**PR-2022-006674**

SD-2023-00197 – PRELIMINARY/FINAL PLAT

VA-2023-00311 – SIDEWALK WAIVER

REQUEST: INTERIOR LOT LINE ADJUSTMENT BETWEEN TWO EXISTING LOTS TO CREATE TWO NEW LOTS, SIDEWALK WAIVER FOR PATRICK AVE

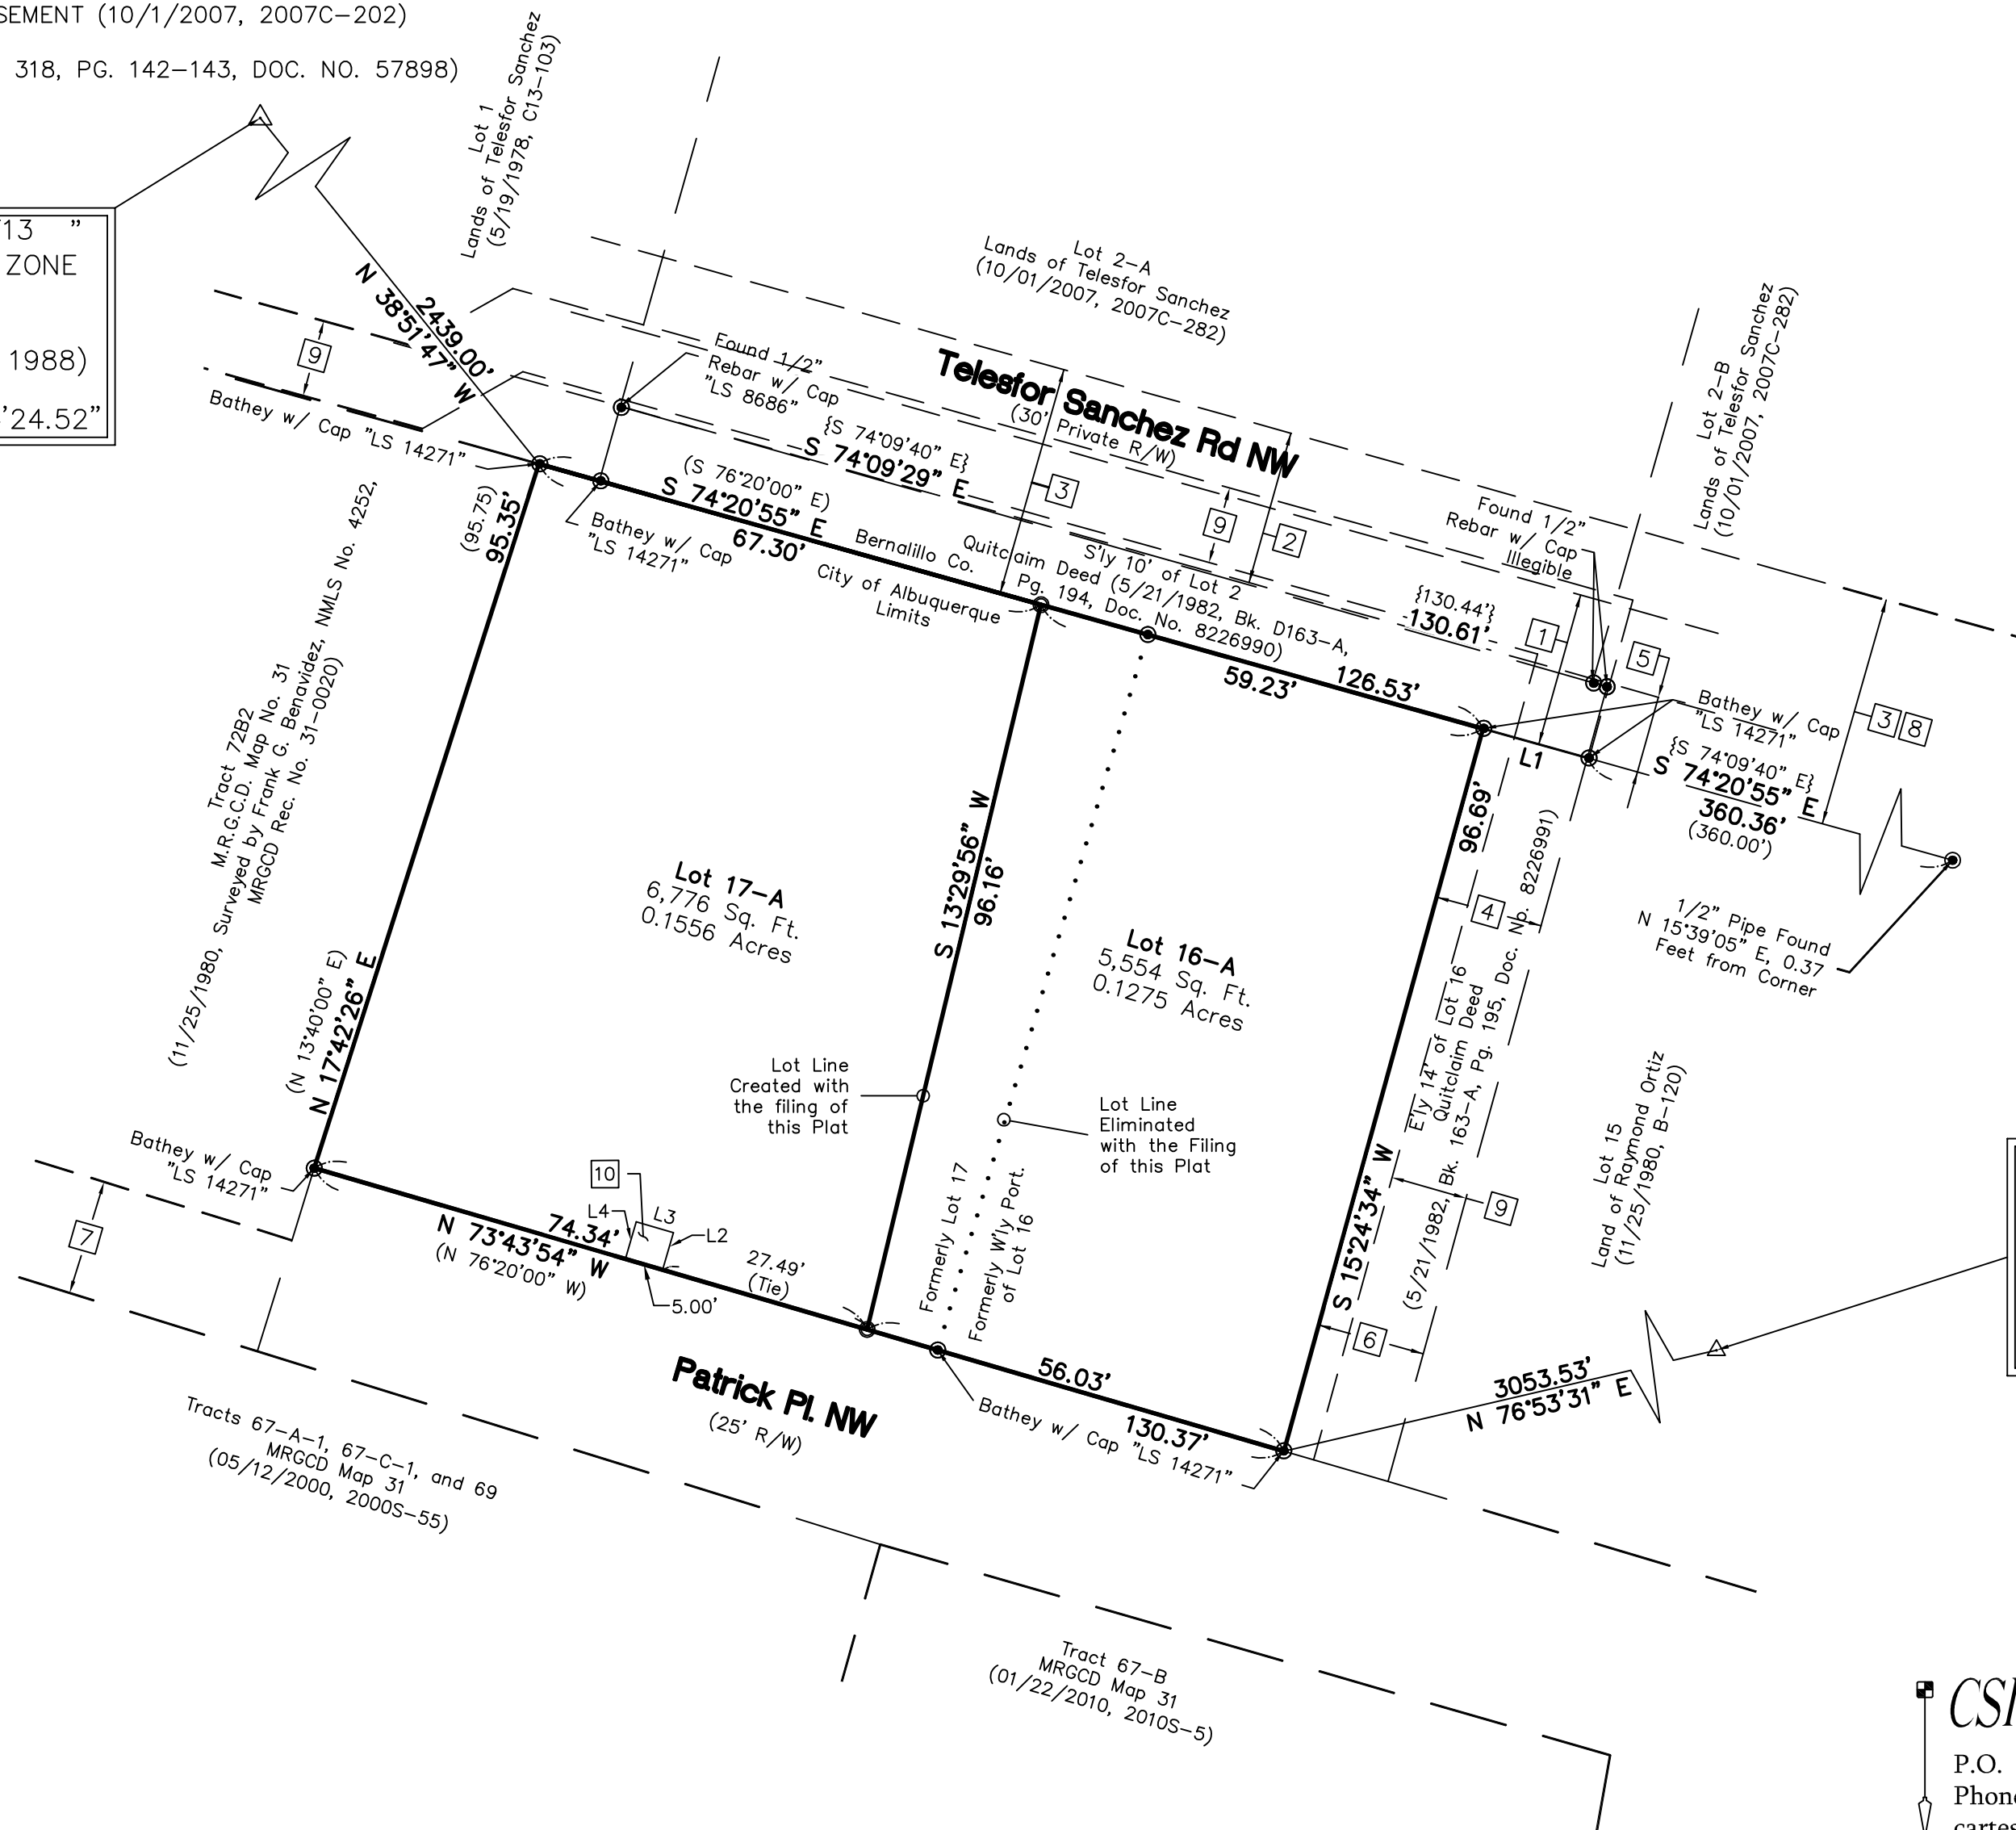
- ~~On Sheet 3 of the Plat, ZHE Variance notes are included from the required 10-foot side yard setback, 75-foot minimum lot width, and lot size requirements. Proof of approval of the ZHE Variances and submittal of the Notices of Decision for the approvals must be submitted prior to the approval of the Plat by the DHO.~~
